Rezoning Transportation Analysis

Petition Number: 2021-118

Revision Log:

Date	Description
09-23-2021	First Review (KP)
11-22-2021	Second Review (KP)
12-28-2021	Third Review (KP)

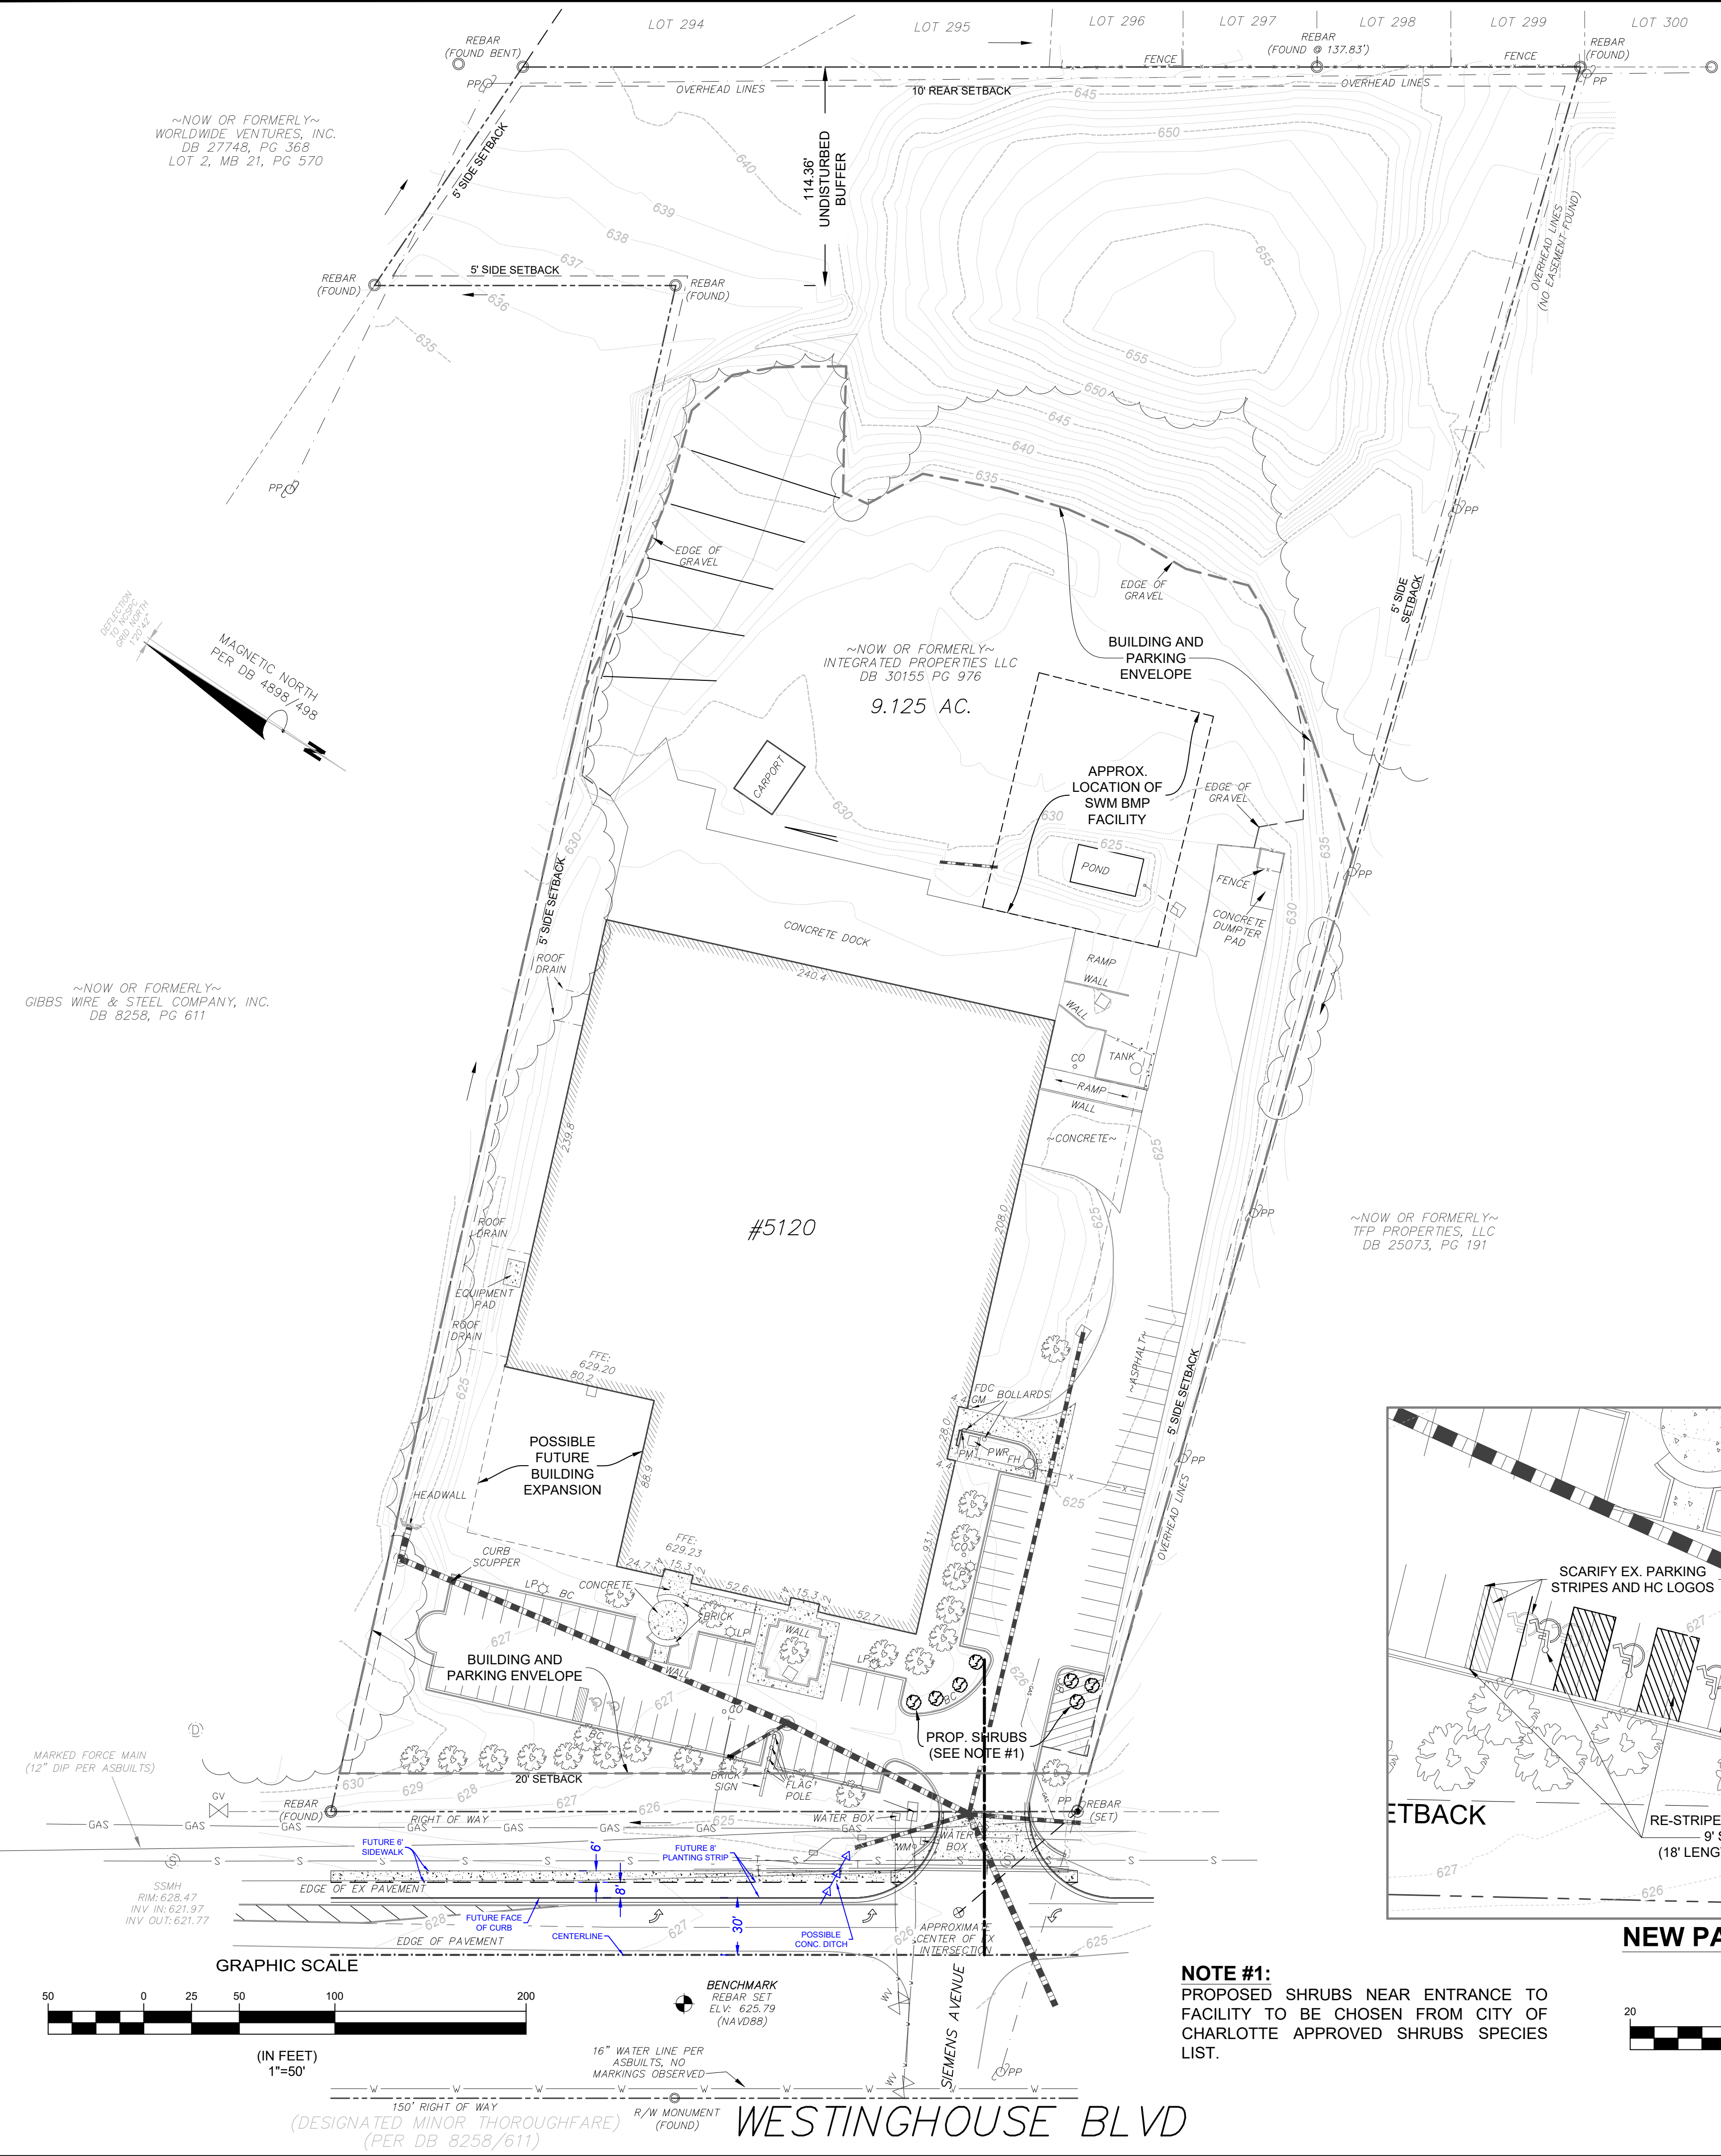
Update to Comment as a Result of the 11-15-2021 Site Plan: Revise the site plan by labeling and dimension the curb line from the centerline to back-of-curb.

Comment resolved after coordination with petitioner: Update to Comment as a Result of the 11-15-2021 Site Plan: Revise the site plan by labeling the sidewalk and planting strip as "proposed".

10. ~~New Comment as a Result of the 11-15-2021 Site Plan:~~ Review and revise the verbiage of conditional note 4.d for accuracy request.
- d. The Petitioner will commit to construct an 8-foot planting strip and a 6-foot sidewalk along the site's frontage of Westinghouse Boulevard. The location of these elements will be measured as 30' from the existing centerline of Westinghouse Blvd. 30' to the future back of curb with the 8' planting strip and the 46' sidewalk located behind and immediately adjacent to the future back of curb. The site plan shall label and dimension these dimensions from the existing centerline. The installation of these improvements are specifically conditioned on the approval of NCDOT.
